From: Simon Davis
Sent: 21 August 2017 17:45
To: 'Dawn Appleton'
Subject: RE: BE/83/17 Land at 24 Ashurst Close Bersted

DRAWING TITLE
Site Plan and Street Elevations

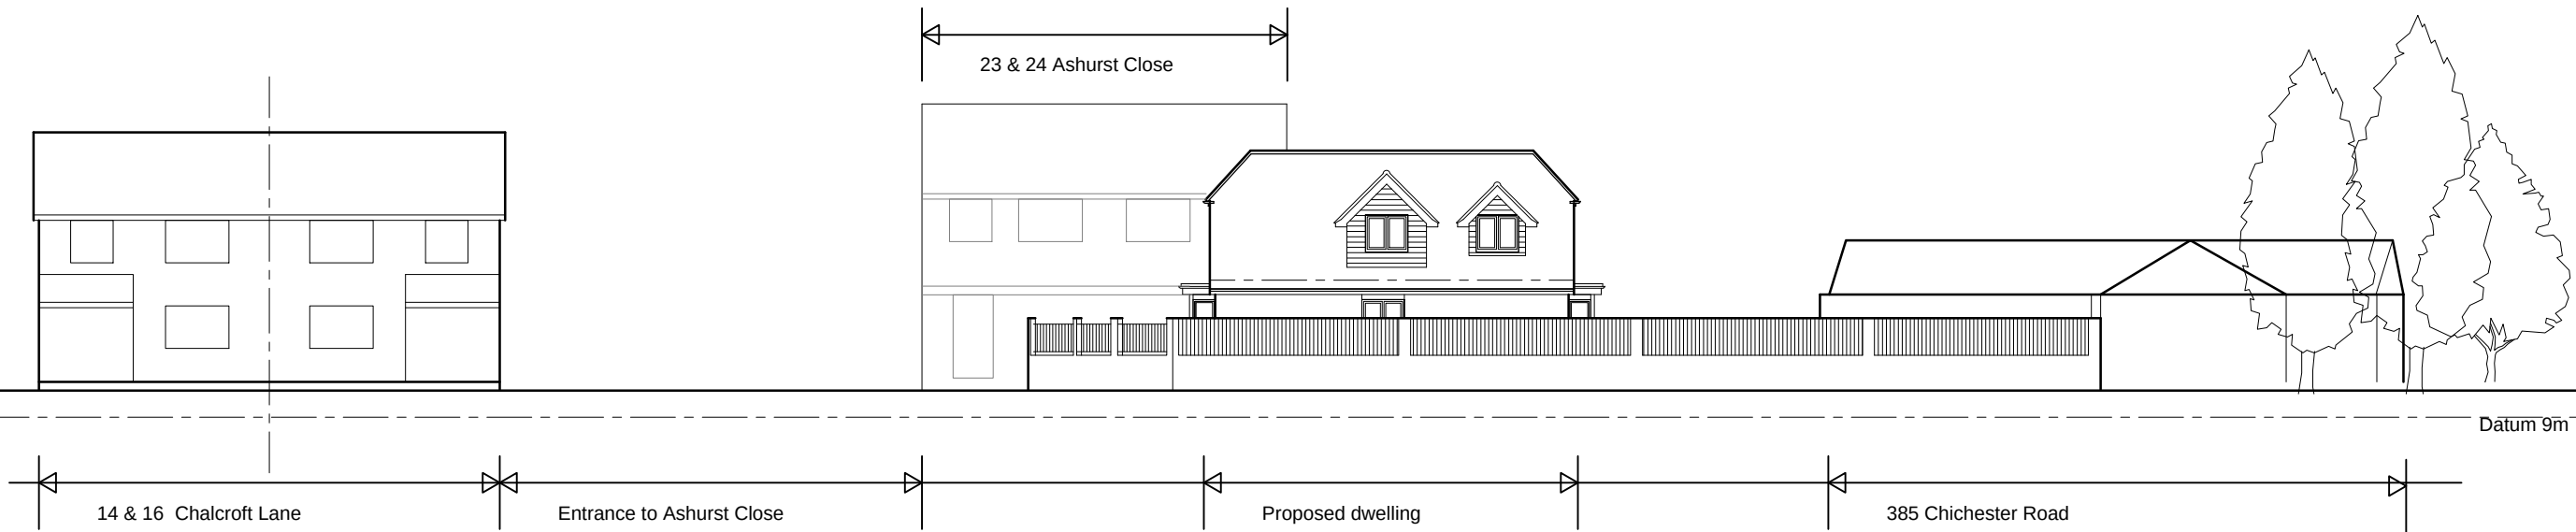
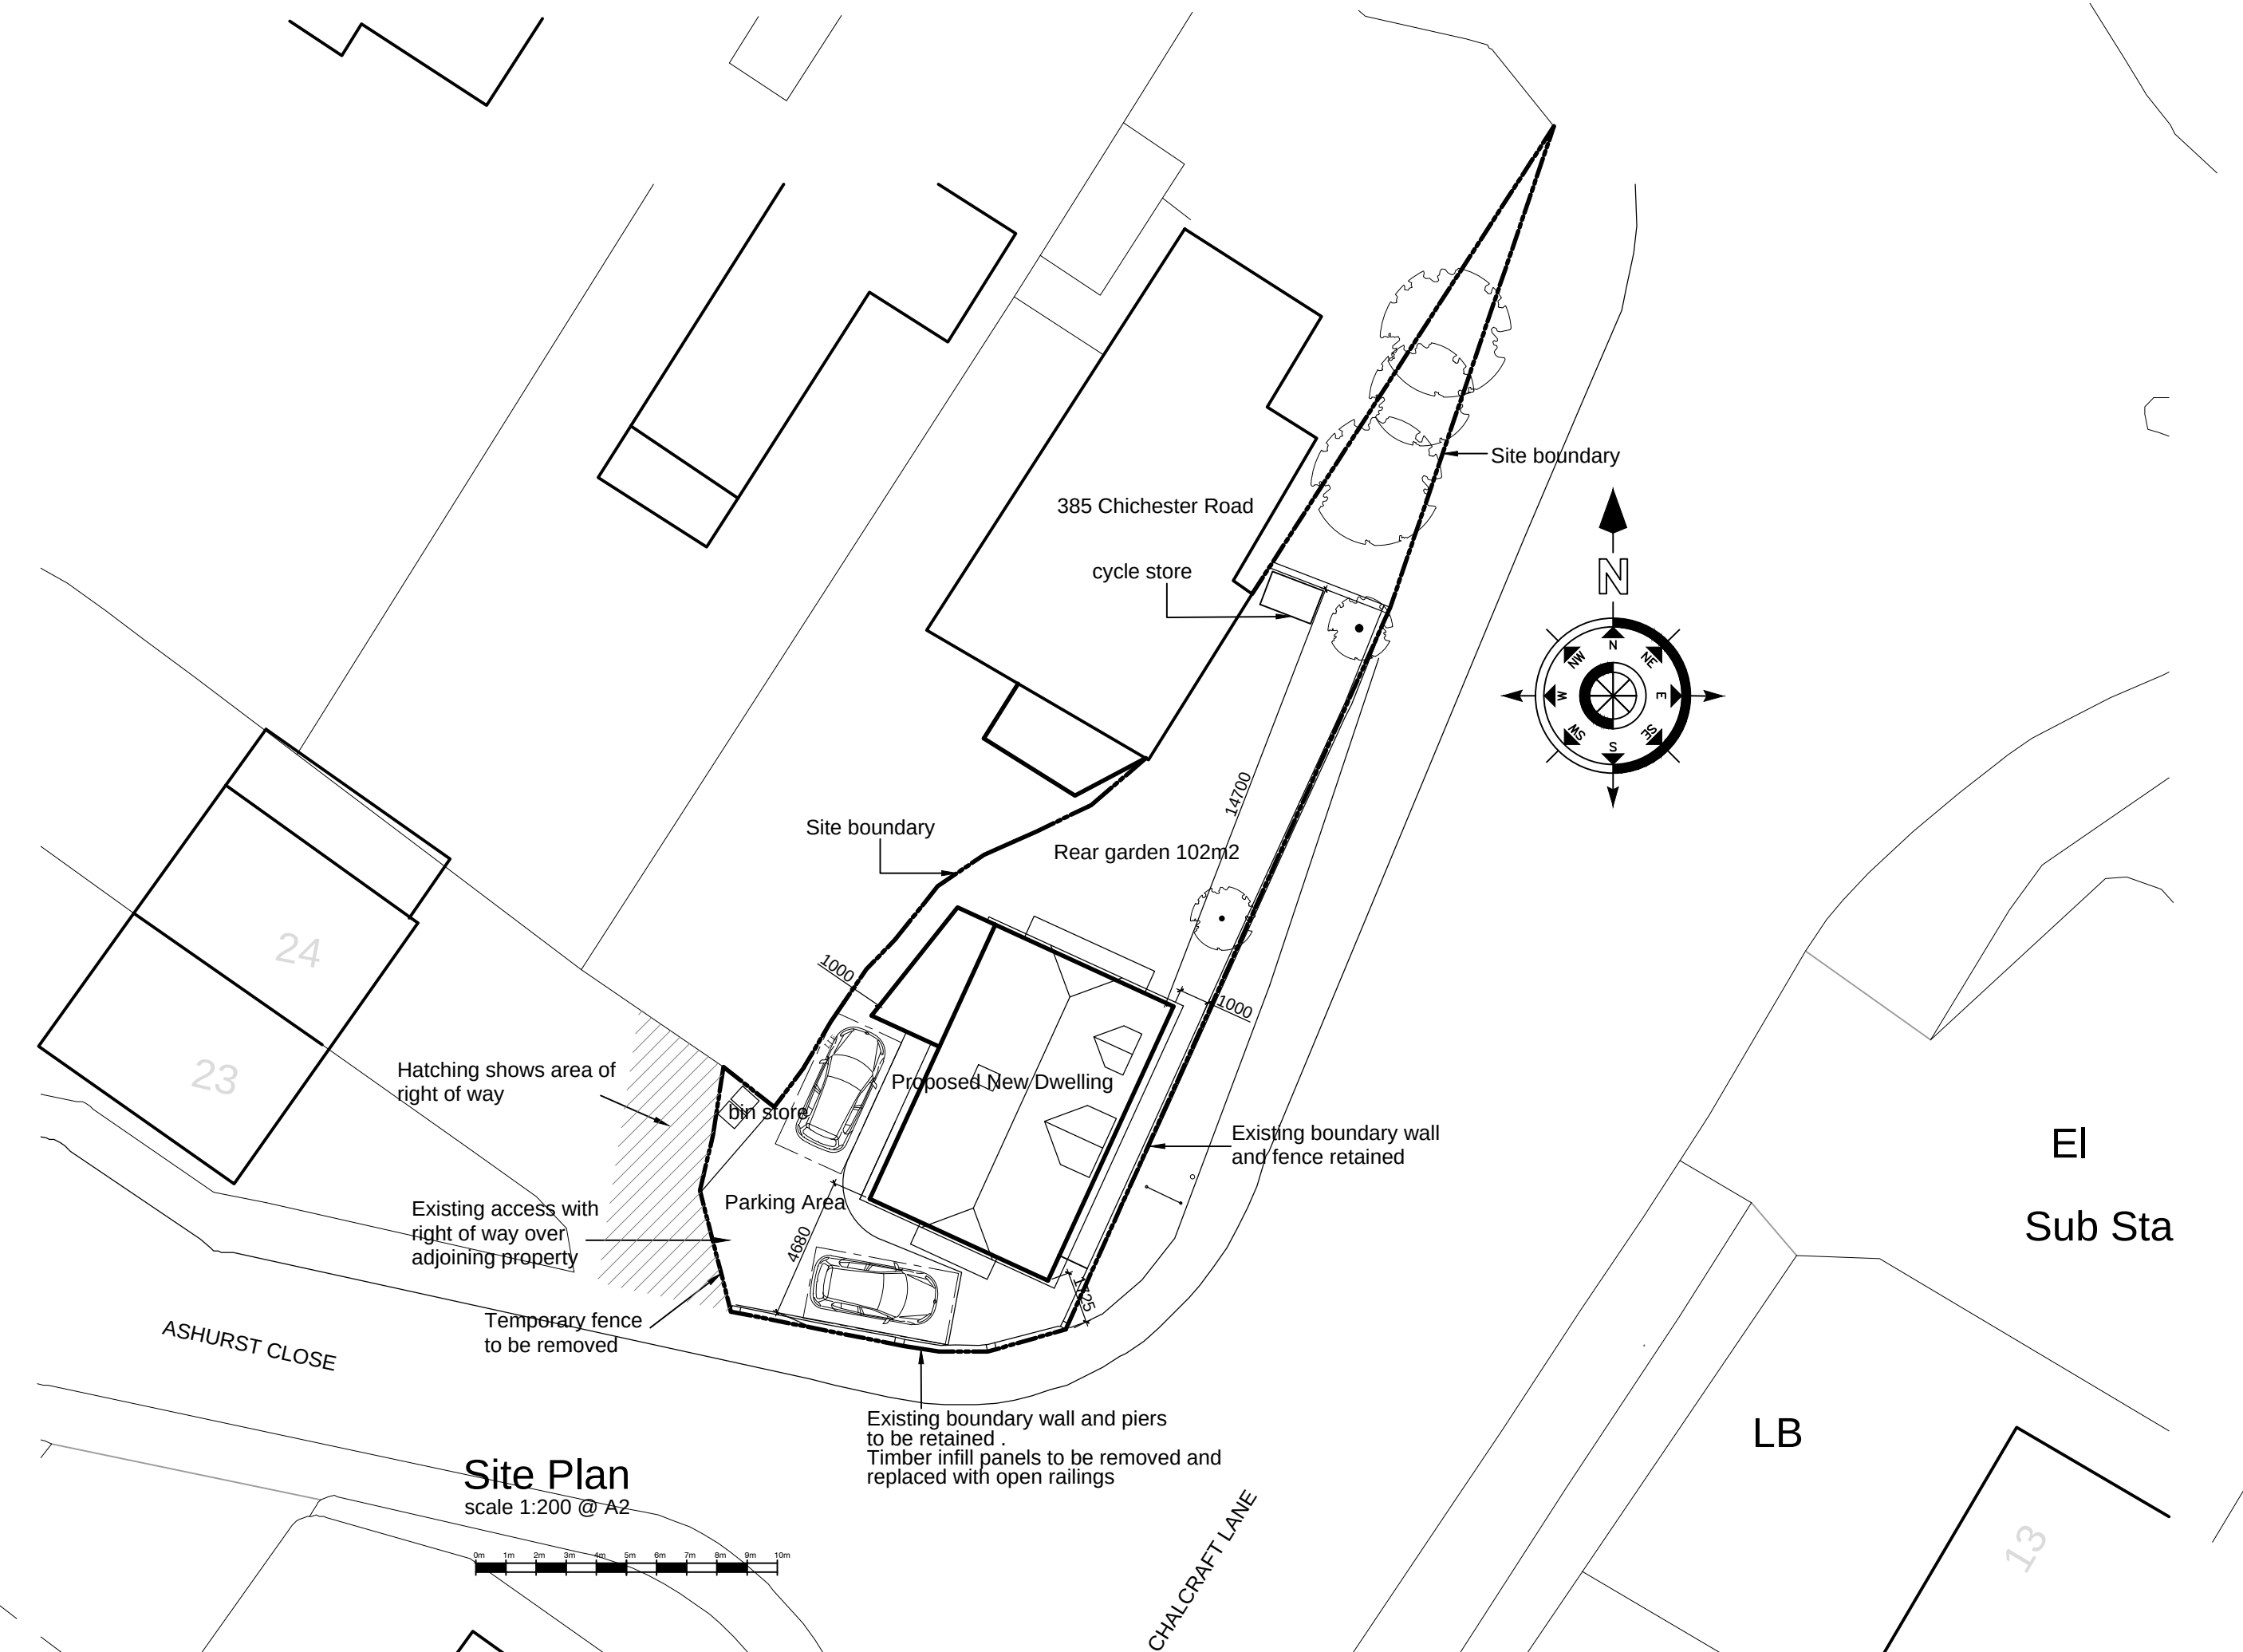
We are minded to recommend the application for refusal based on its position close to the boundary with Chalcraft Lane – and therefore the impact on the established streetscene. The dwelling will also be higher and to the south of 385 thus potentially affecting the light reaching their rear garden. I also consider that due to the existing windows in the eastern side of 385, that part of the proposed garden area will not be private.
